June 13, 2012

Project# 1009046

12DRB-70115 MAJOR - PRELIMINARY PLAT APPROVAL

MARK GOODWIN AND ASSOCIATES, P.A. agent(s) for SAWMILL CROSSINGS, LLC request(s) the referenced/ above action(s) for Tract B1A2, **DUKE CITY LUMBER CO ADDITION**, zoned SU-2/S-I (proposed SU-2/ SU-1 PRD), located on the south side of ASPEN AVE NW between 12TH ST NW and 19TH ST NW containing approximately 6.9292 acre(s). (H-13)[*Deferred from 5/2/12, 5/23/12, 6/6/12*]

PRELIMINARY PLAT FOR  
**SAWMILL CROSSING**  
**UNIT 1**  
WITHIN THE  
TOWN OF ALBUQUERQUE GRANT  
PROJECTED SECTION 7  
TOWNSHIP 10 NORTH, RANGE 3 EAST, N.M.P.M.  
CITY OF ALBUQUERQUE BERNALILLO COUNTY, NEW MEXICO  
MARCH, 2012

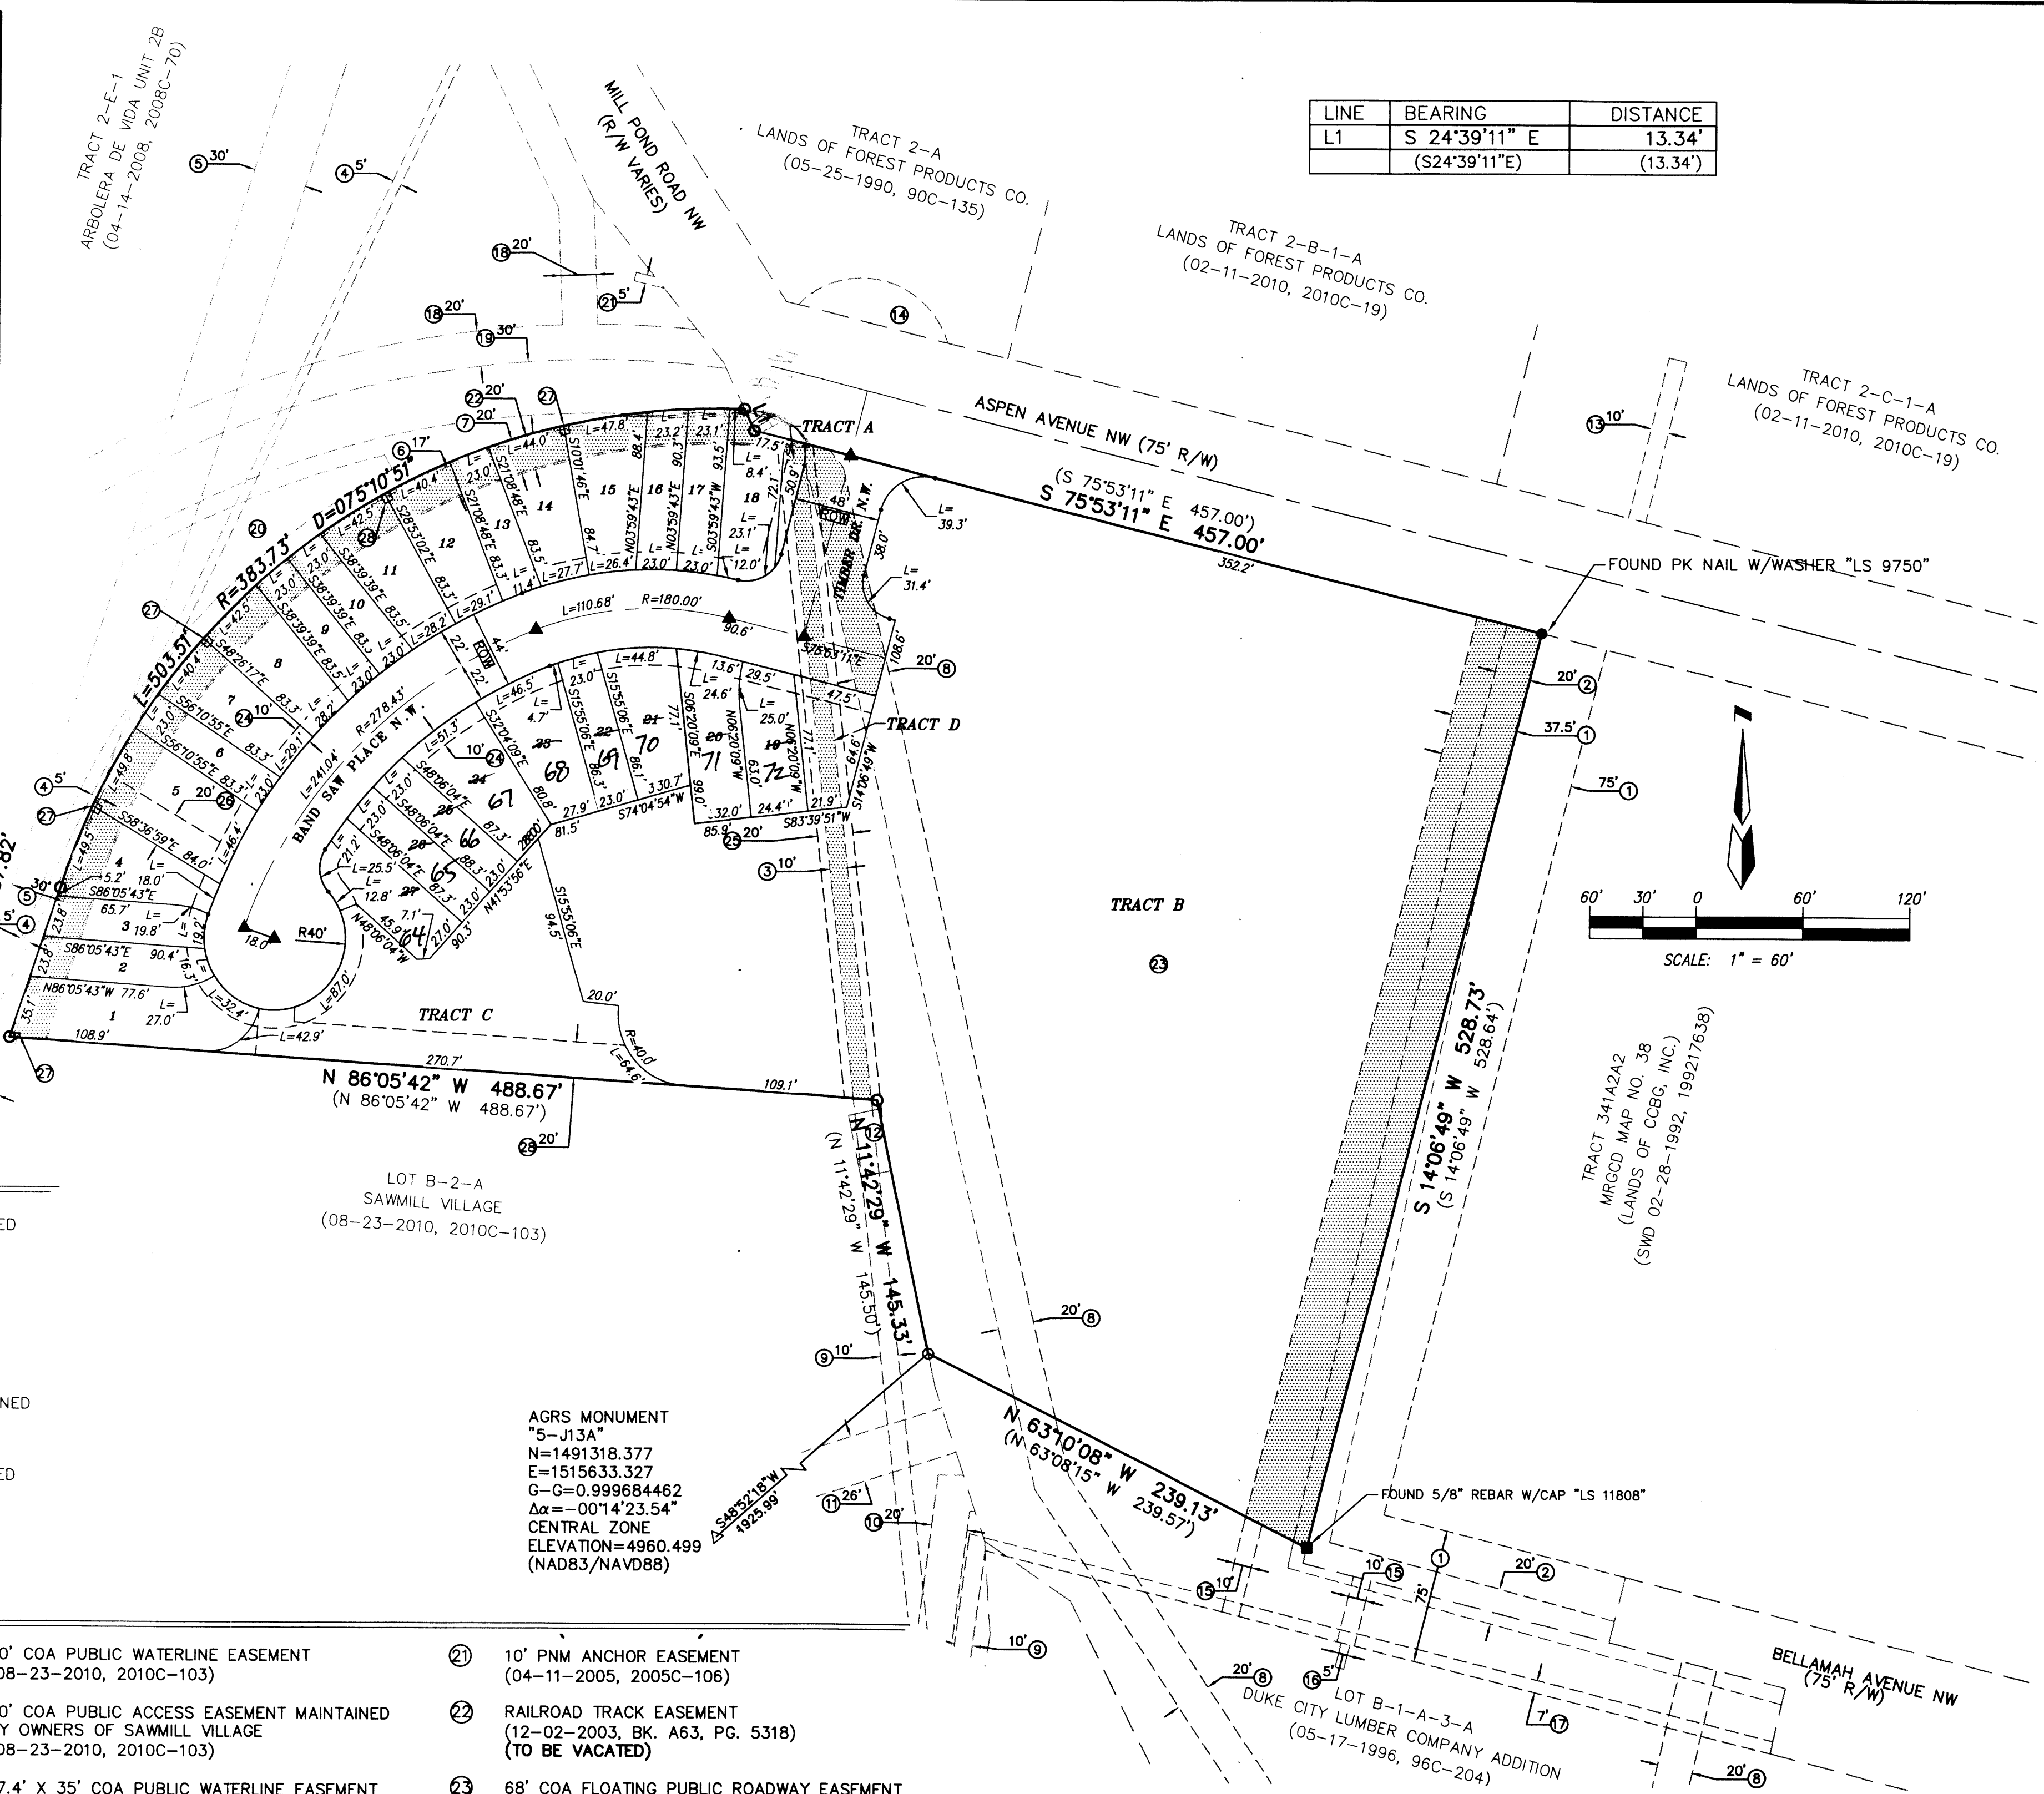
- The Tri-Party Agreement between the developer, the City of Albuquerque, and the NMDOT is required prior to Final Plat.
- The railway crossing must be approved prior to Final Plat.
- Note 9: Show the 3 foot easement on Tract B and it will also be required to be shown on Tract C on the Final Plat.
- Note 10: The sidewalk culverts should be maintained by the property owner on the lot where the sidewalk culvert is built. Change the note by ending the sentence after the word "...owner" on the Final Plat
- A recorded SIA is required prior to applying for Final Plat.
